RE: Event Center
1611 Airtech CT. SE
Comments dated May 28, 2024
Hydrology File: N15D017

This letter is a response to the comments dated May 28, 2024, and is being provided with the grading plan resubmitted with engineer's date 6/20/2024. Please refer to the response under each comment.

LANDSCAPING
PLAN

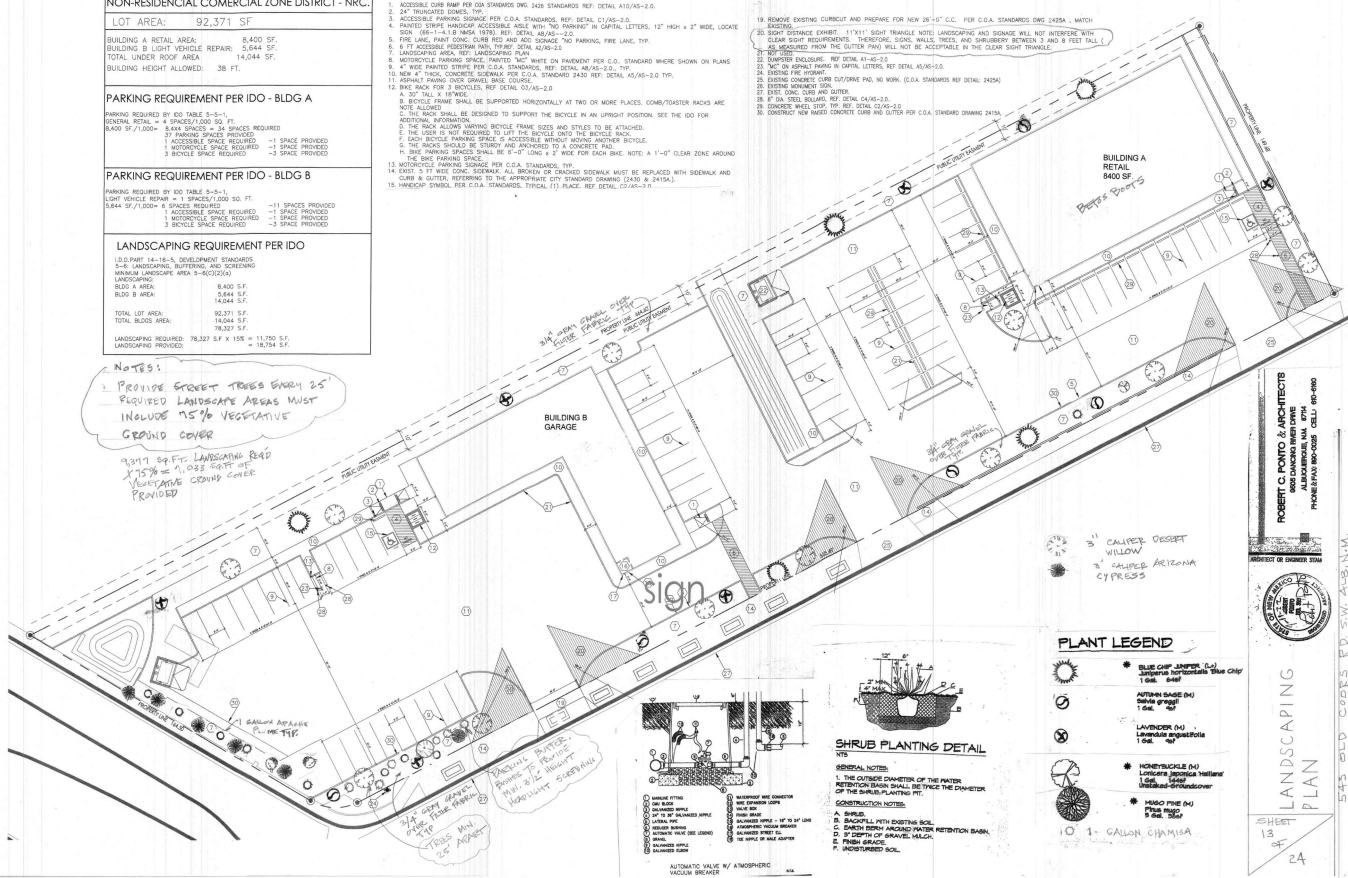
Comment 2: Please provide Motorcycle parking sign posted upright sign, either free-standing or wall mounted per the zoning code.

Comment No. 3: Per site visit new parking spaces have been provided on south side of the site. Please red mark the site plan to reflect this changes.

➤ Response: Contractor installed. See picture below.

➤ Response: See redline on TCL Certification dated 6/25/2024.
